A30 Chiverton to Carland Cross TR010026

8.19 COMMENTS ON INTERESTED PARTY SUBMISSIONS AT DEADLINE 4

June 2019

Drawing Title: FIGURE 7.6 - ENVIRONMENTAL MASTERPLANS SHEET 6 OF 20

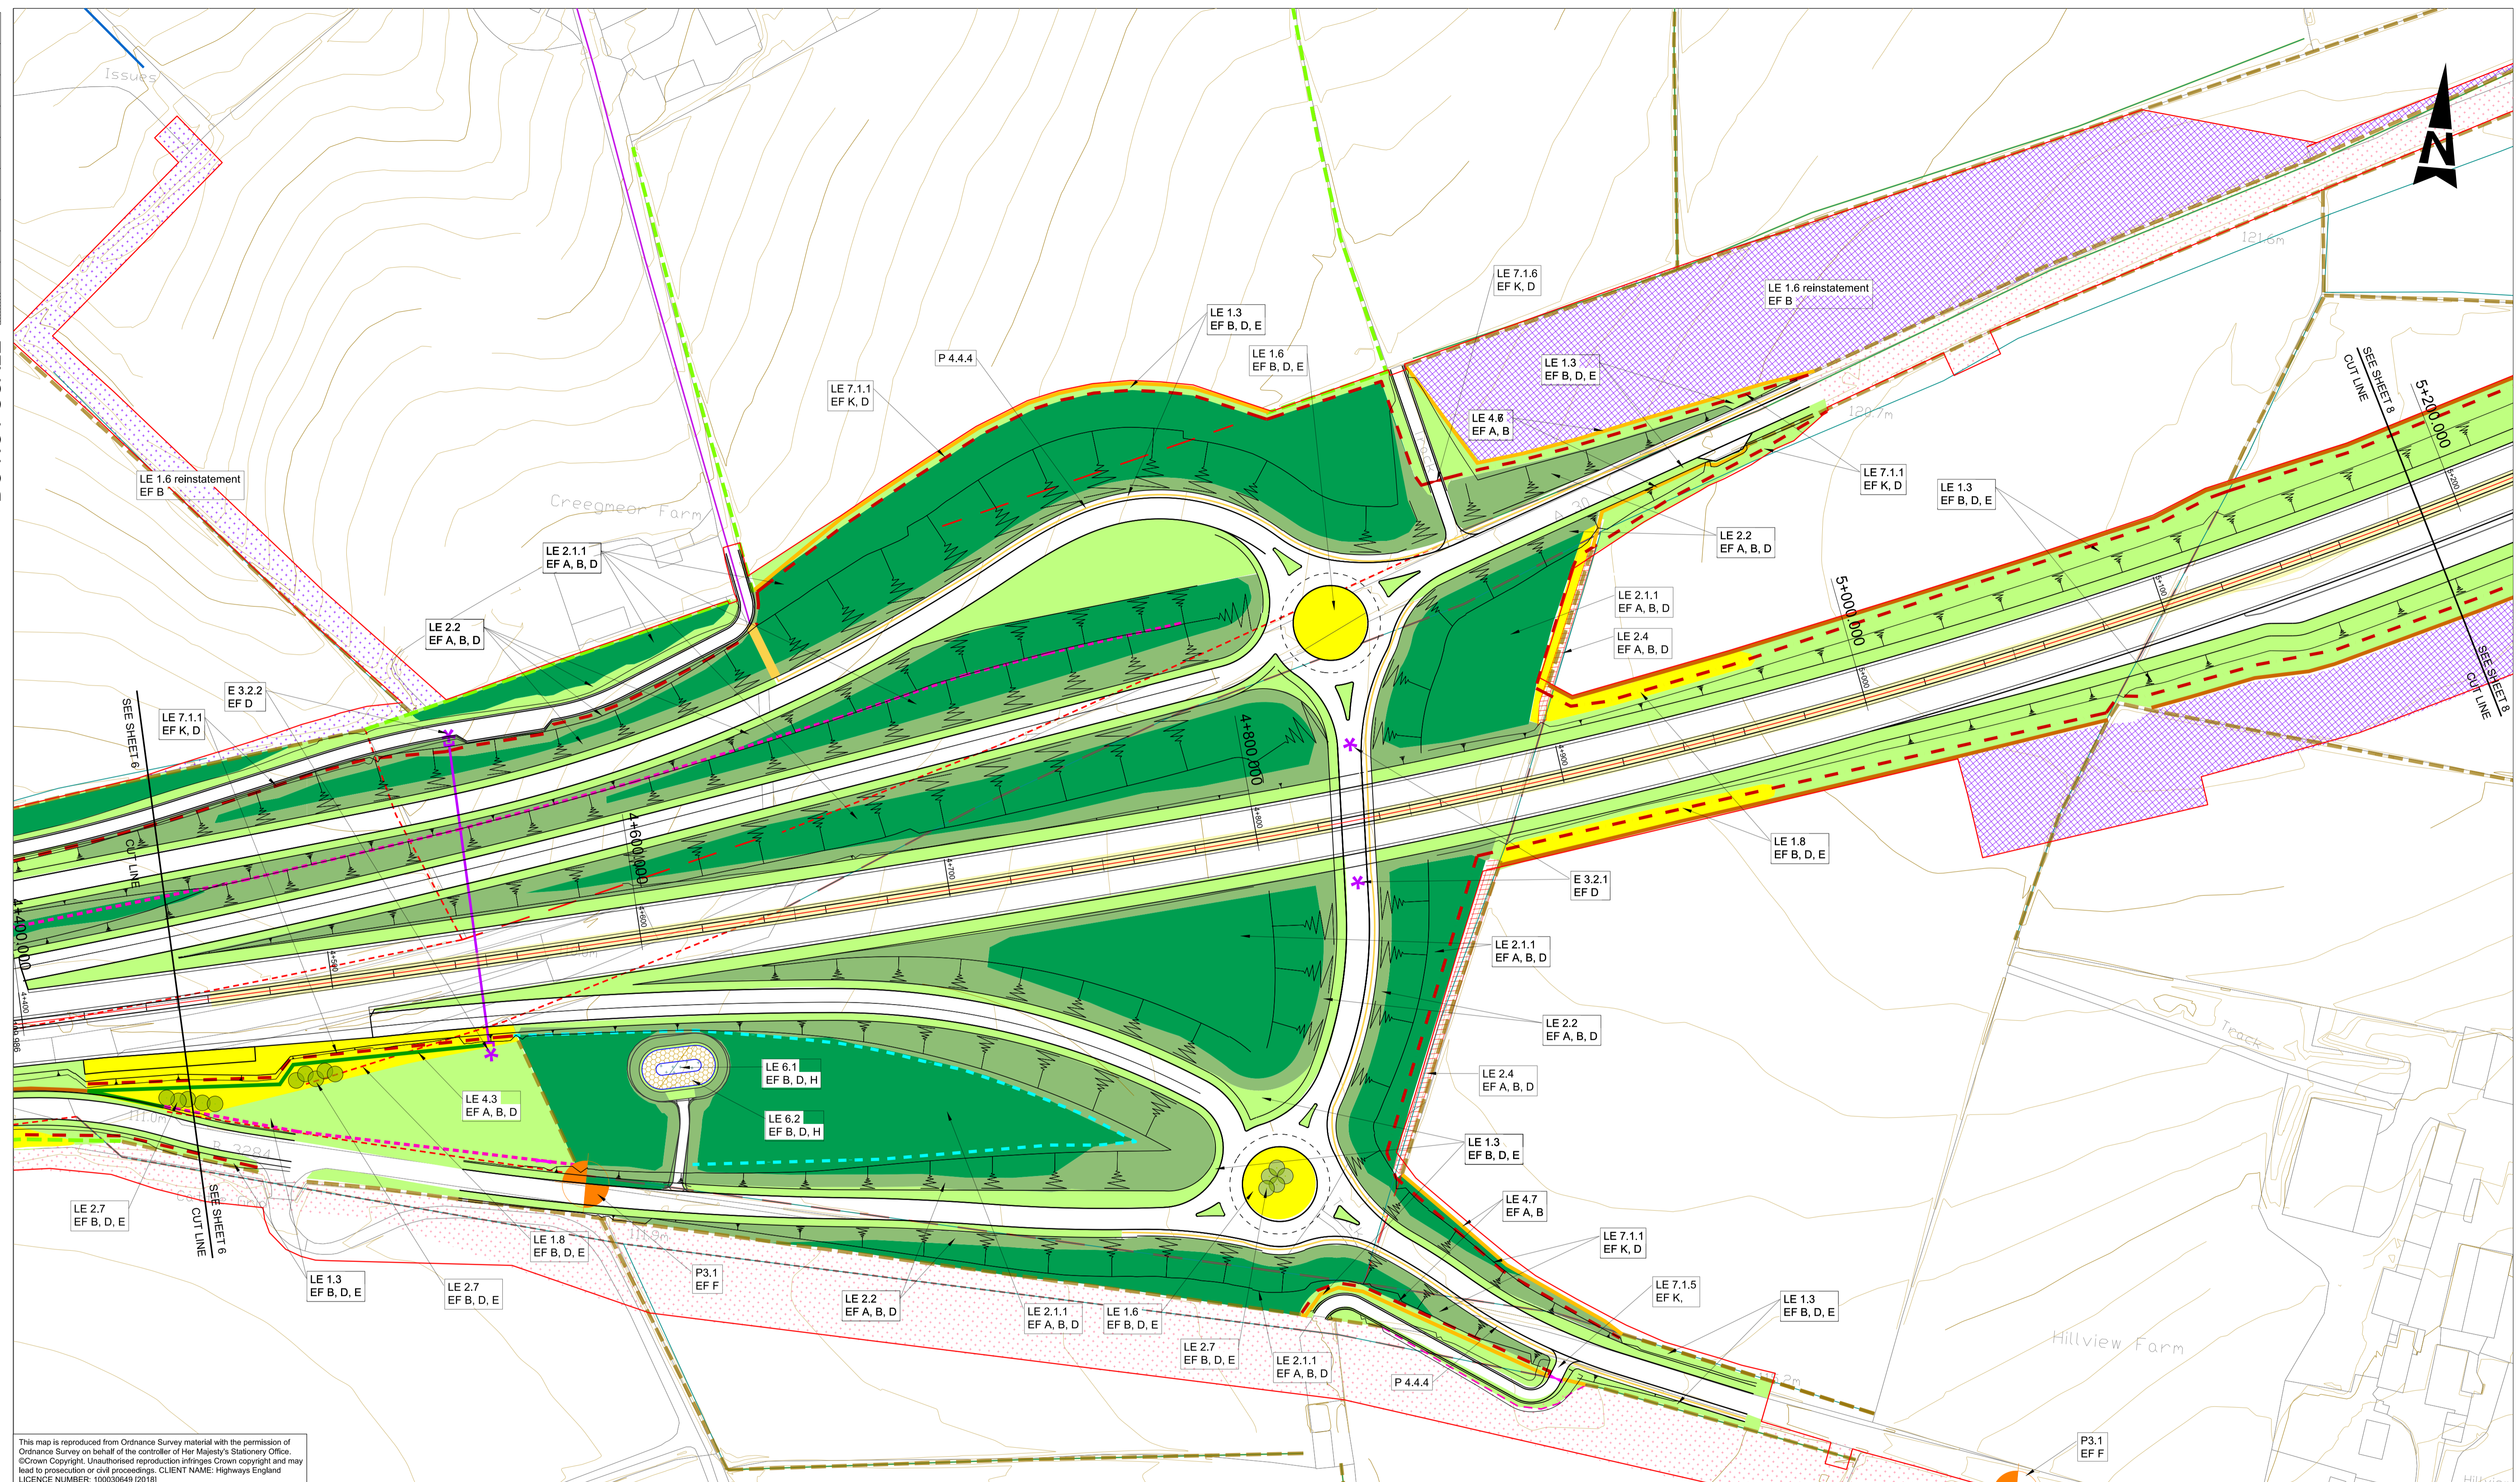
3.	Access to meadow from Pennycomequick Lane (C0075).	<p>Highways England has updated the relevant documents to include an access to the wildflower meadow opposite the proposed access to Pennycomequick residence:</p> <ul style="list-style-type: none"> • Sheet 6 of the Works Plans (Document Reference 2.4(B)) [REP2-006] • Sheet 6 of the Rights of Way and Access Plans (Doc Ref 2.5(B)) [REP2-011] • The Draft DCO (Doc Ref 3.1(C)) [REP2-012] • Appendix A of the Statement of Reasons (Doc Ref 4.1(A)) [AS-032] <p>These changes were submitted to the Planning Inspectorate for Deadline 3 of the Examination, on 24 April 2019.</p>	It is agreed that these changes resolve the concern raised by the Harvey Family.
